Consultation Response from KC, Highways Development Management
2026/90774 39, Sycamore Way, Birstall, Batley, WF17 0EE
Erection of single and two storey side and rear extension and alterations to parking
Date Responded: 28 August 2026 Responding Officer: Sheila Henley Responding Ref: 13-3SE/22

Plan ref: Proposed Site Plan Rev B.

PROPOSED SITE PLAN

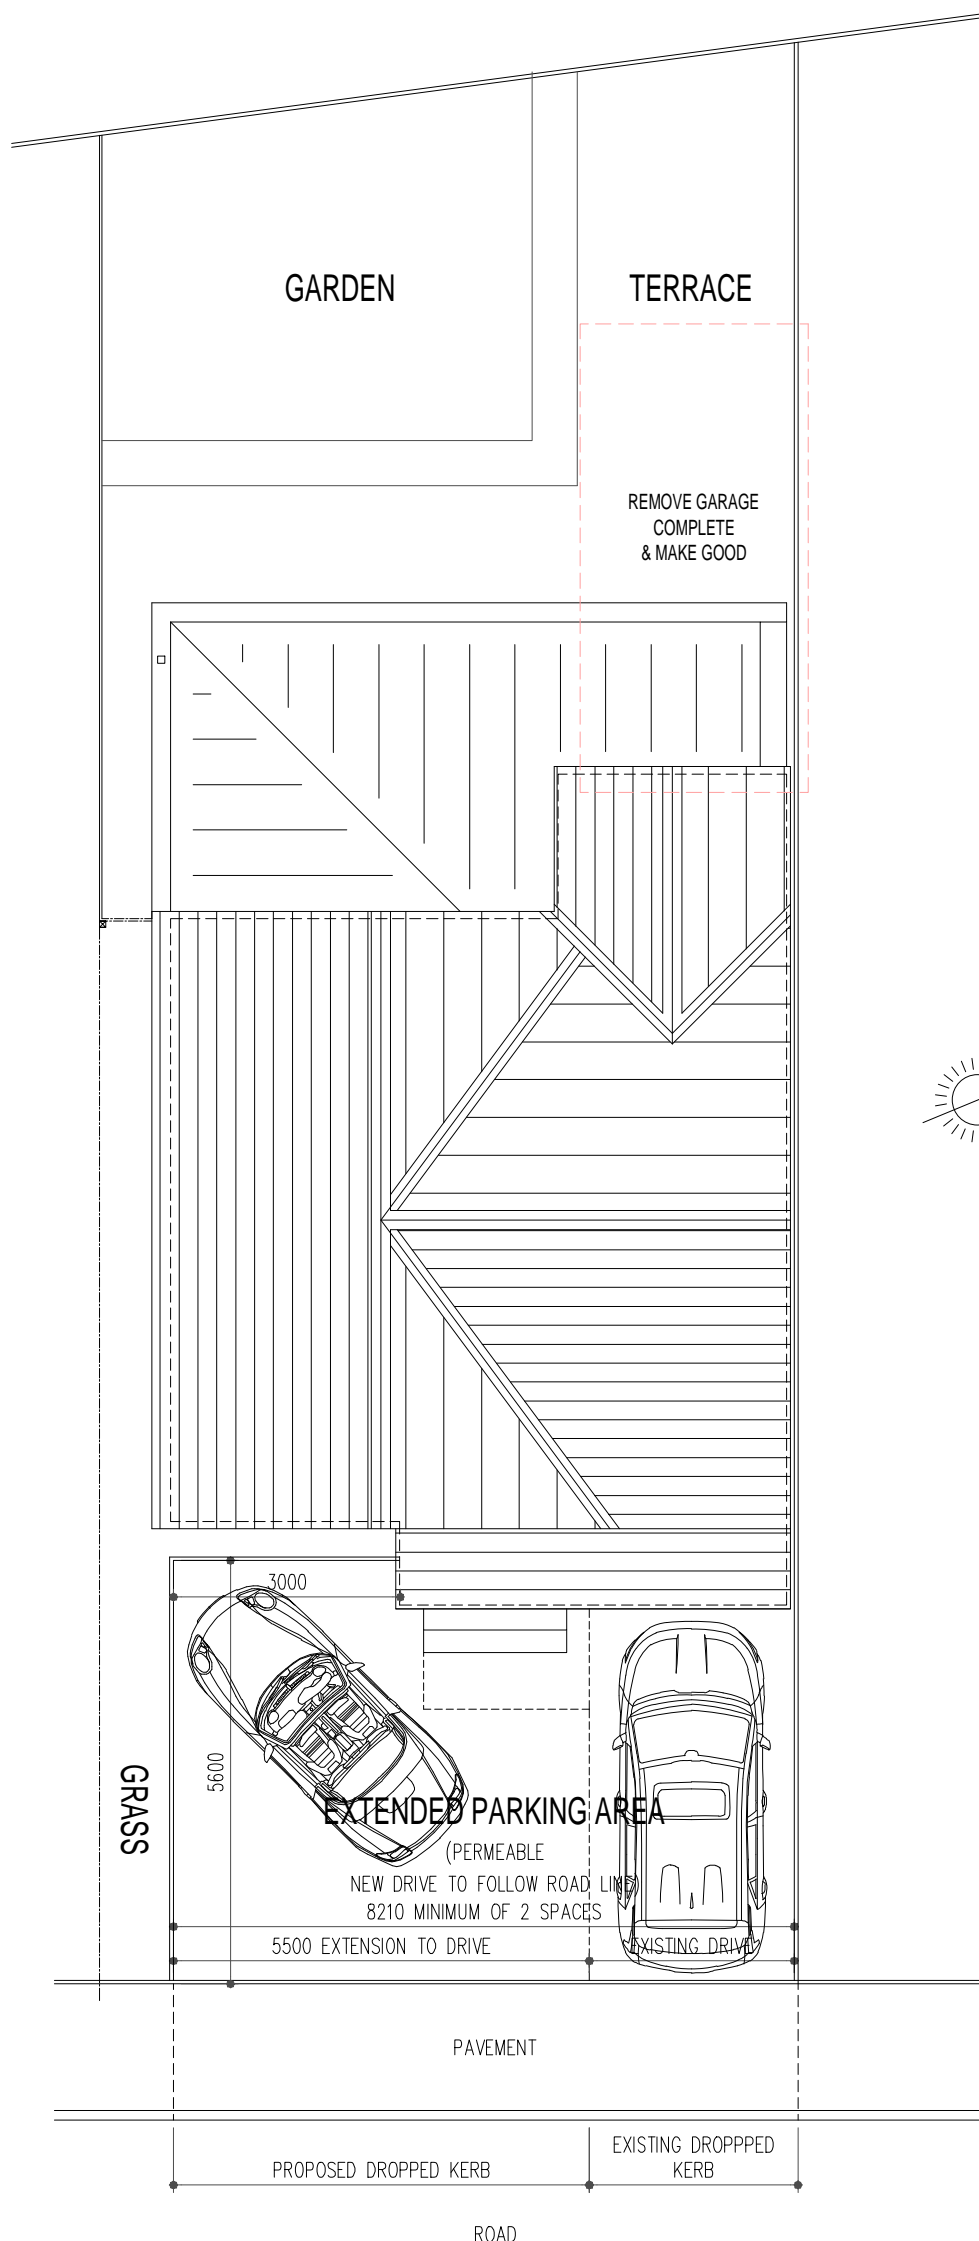
HDM acknowledges that the revised site plan, Rev B, adjusts the ridge height of the roof without further revision to the intended access and parking arrangements now approved as of 7 August 2026. The planned access and parking layout includes extension of the existing dropped kerb, widening of the access, full use of the front garden for car parking surfaced in a permeable material, and an integral garage.

The widening of the access and extension of the dropped crossing of the footway would provide a suitable means of access. The dropped crossing would need to tie with the neighbouring one at no. 37 to avoid trip hazards under a separate permission from Highways. Refer:
<https://www.kirklees.gov.uk/beta/transport-roads-and-parking/dropped-kerbs.aspx>

The dimensions of the exterior on-site parking are suitable for the parking of two cars with porous surface material negating the need for surface water drainage. The garage is significantly less than the typical internal size of 6.0 x 3.0m for a single garage at 4.5 x 2.2m (1.4m wide when door is open). At this size, the intended garage cannot count towards car parking but would be adequate for the storage of bicycles and other items. Cycle parking would encourage mode choice and Active Travel objectives and support policies LP20 and LP22.

There would be a reduction in car parking on-site to two spaces with the loss of the existing garage and parking provision to the side of the property and partly to the front as well as the front garden space. Typically, the amount shown is less than expected for a four bedroomed unit after accounting for the extension where three spaces would be the norm under the Kirklees Highway Design Guide SPD. Some flexibility is possible to meet policy LP22 with use of on-street provision. Yet, there is limited on-street space available along the residential street, and it should not obstruct neighbouring access and is on a first come first served basis without guarantee of parking outside of the property. Whilst Sycamore Way is not a classified road and there is no traffic regulation order in place restricting on-street parking, use of the footway is prevalent potentially obstructing and inconveniencing pedestrian movements, and the Applicant is reminded that appropriate parking should occur on street in accordance with the Highway Code.

**PROPOSED SITE PLAN**

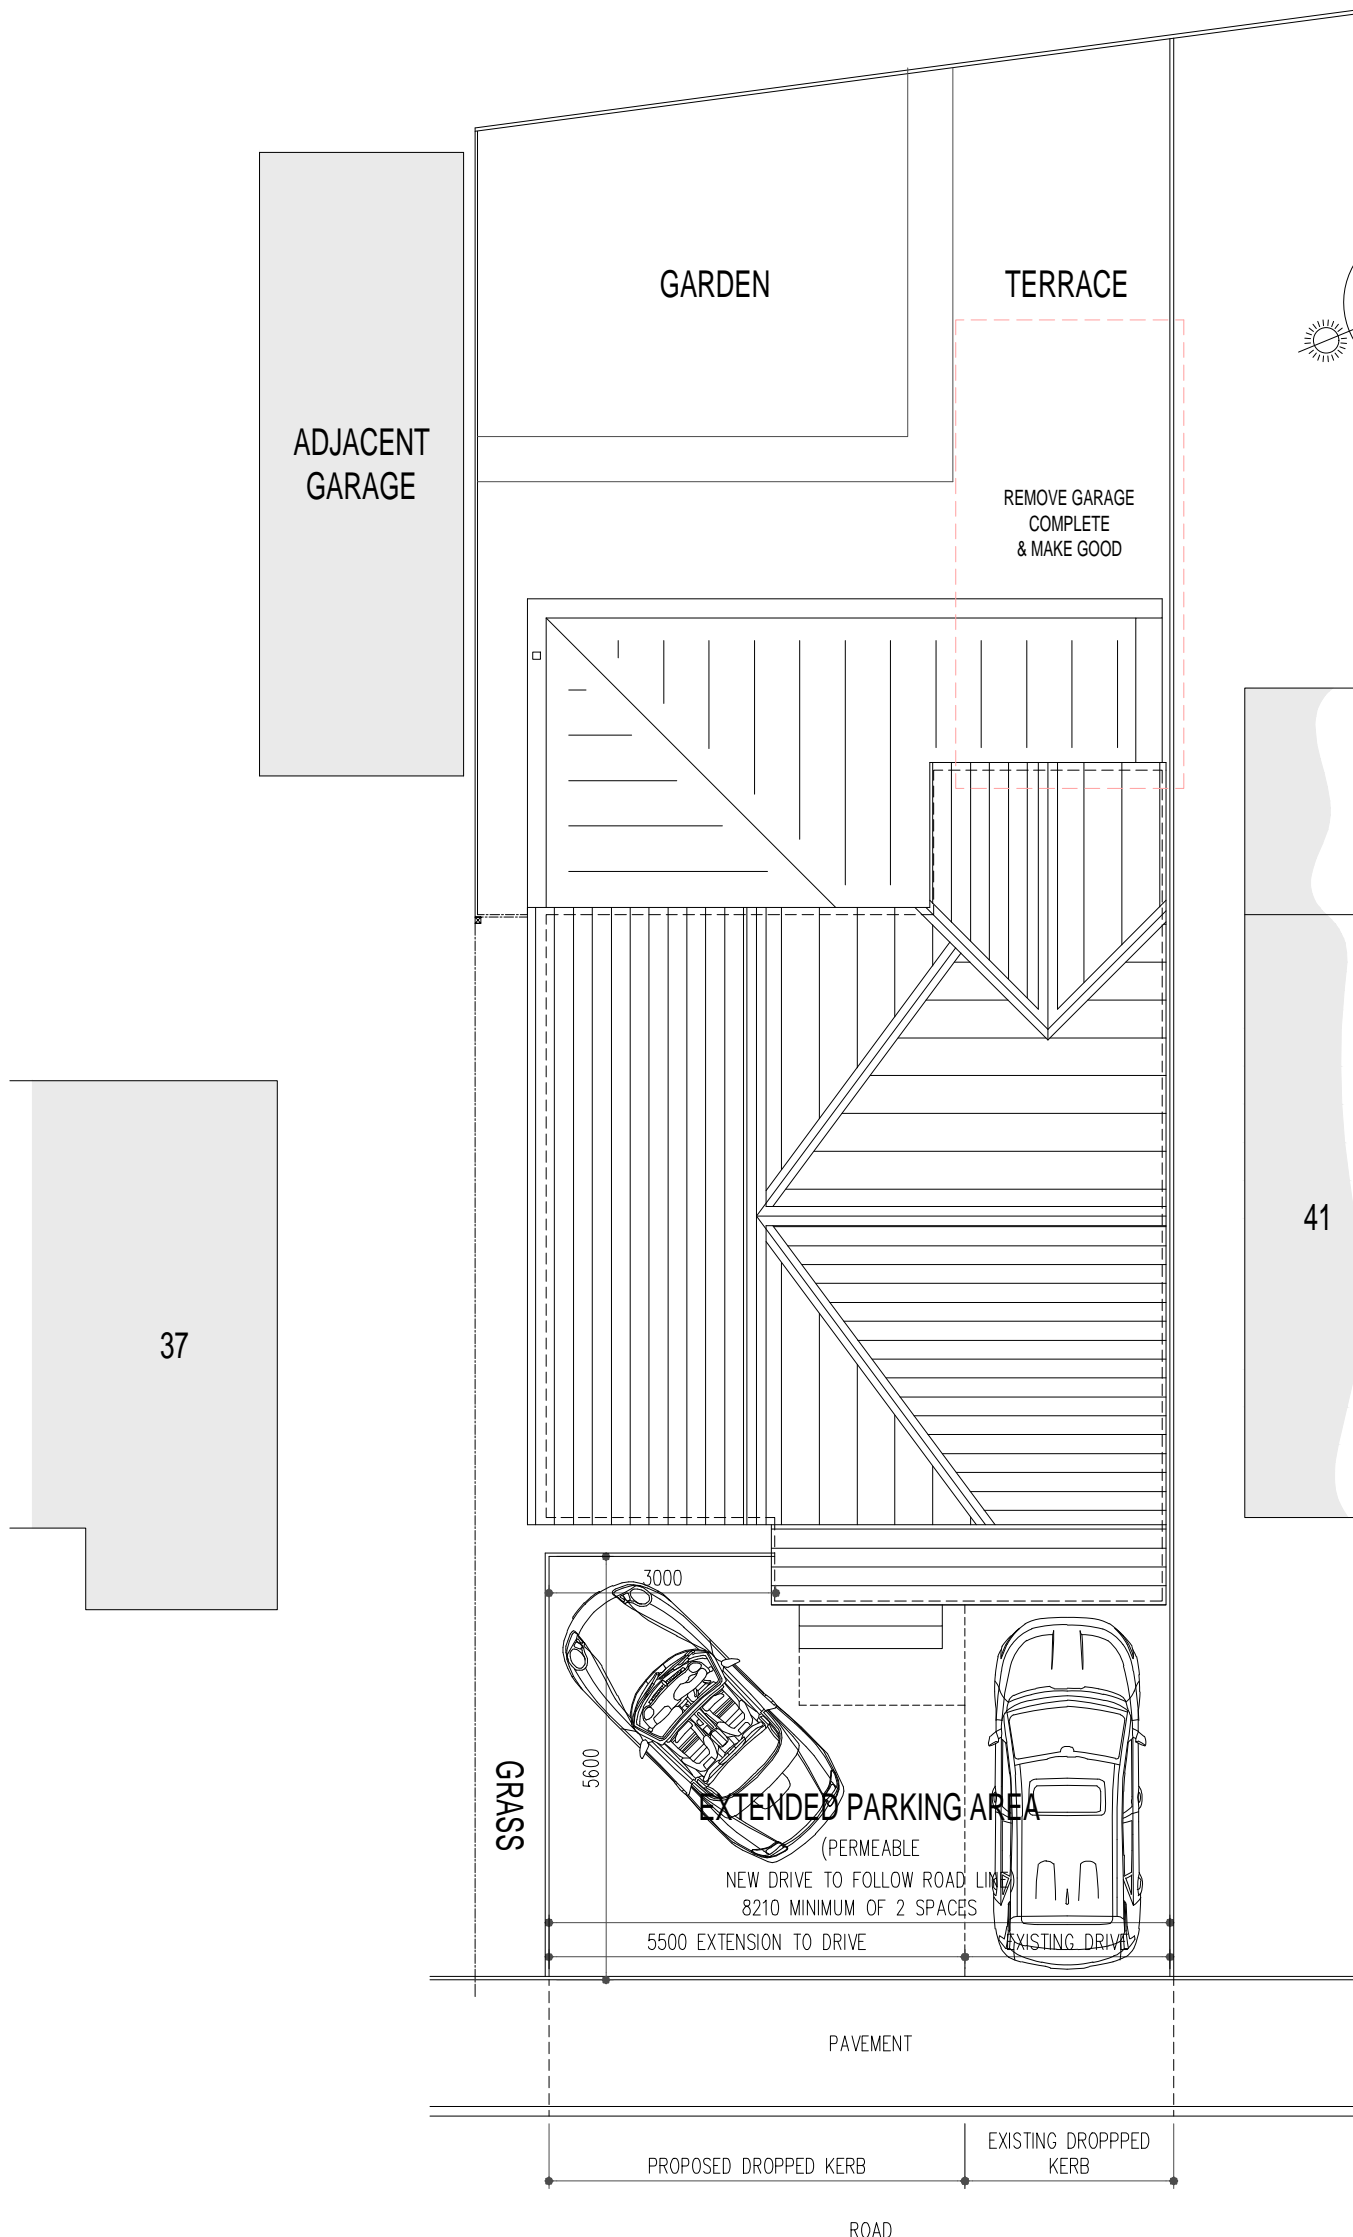
Use of the entire front garden for hardstanding and car parking is a matter for the LPA.

The Applicant should consider installing an electric vehicle charging point to support sustainable travel and the lowering of emissions in accordance with policies LP20 and LP22.

Space would remain for bin storage for kerbside collection.
